DELEGATED DECISION FOR APPLICATION FOR CERTIFICATE OF LAWFUL DEVELOPMENT

Reference no.: 2023/CL/91427/W

Site: 593, Bradford Road, Fixby, Huddersfield, HD2 2LA

Description: Certificate of lawfulness for proposed internal alterations including installation of two ensuite bathrooms to the first floor and new staircase from first floor to the loft space and the creation of bedroom and ensuite with five no. Velux roof windows

SE ELEVATION AS PROPOSED - 1:100

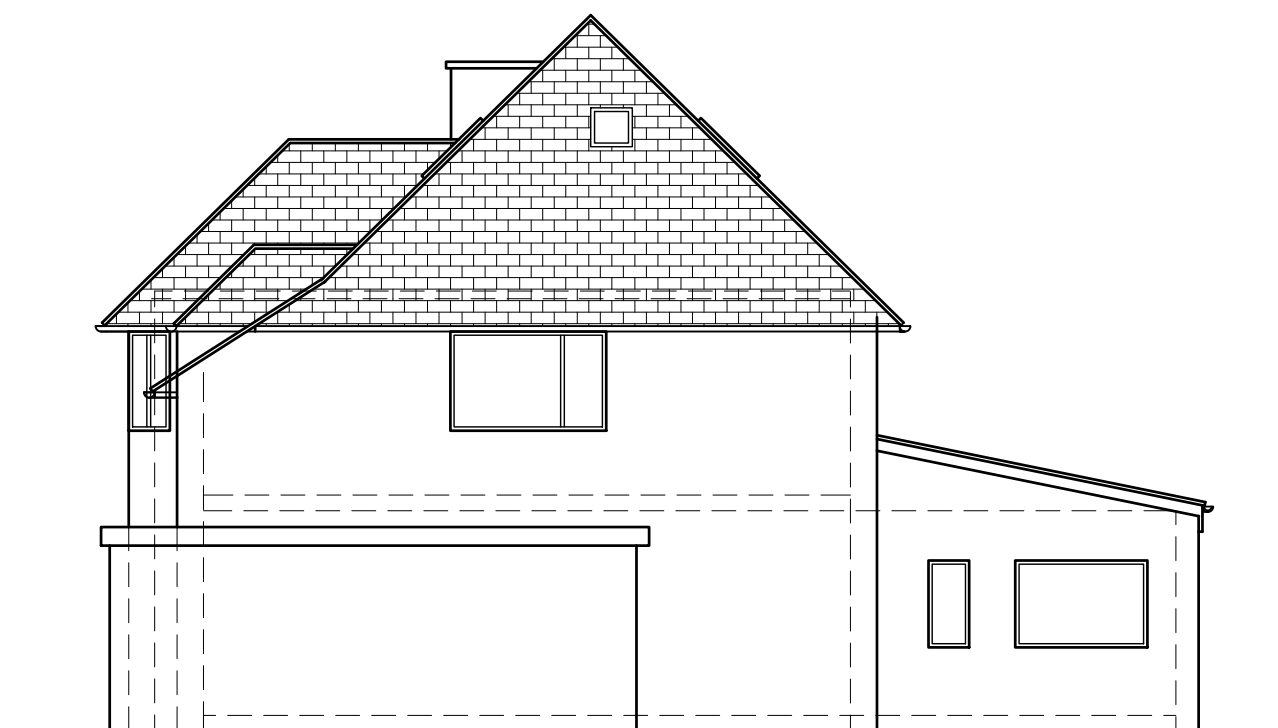
Two roof windows are proposed on the front elevation, two on the rear and 1 on the South-eastern elevation. The South—western window would obscure glazing to conform with condition C.2 of the Town and Country Planning (General Permitted Development) (England) Order 2015 (as amended).

Comment: Rooflight on side elevation (South-East) would be obscurely glazed and 1.7 metres above the Floor (confirmed by the applicants planning agent by email dated 10th July 2023).

LOFT FLOOR PLAN AS PROPOSED - 1:100

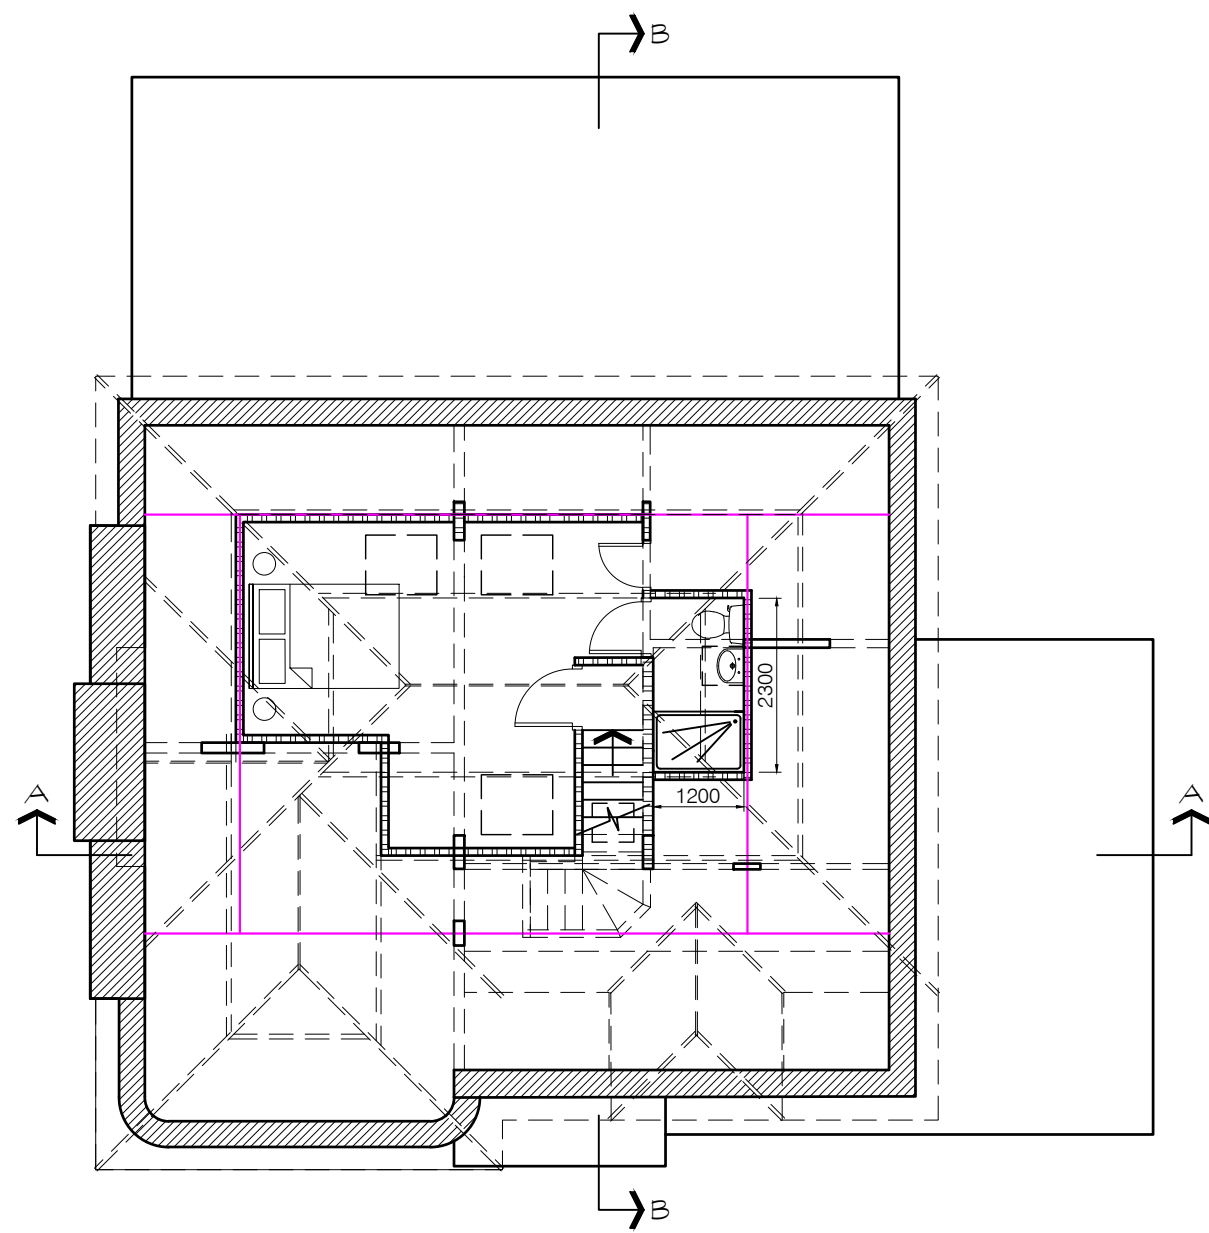
Comment: *Windows and rooflights to be installed do not increase any height of the existing roof.*

Comment: *Windows and rooflights to be installed do not extend any part of the existing roof.*
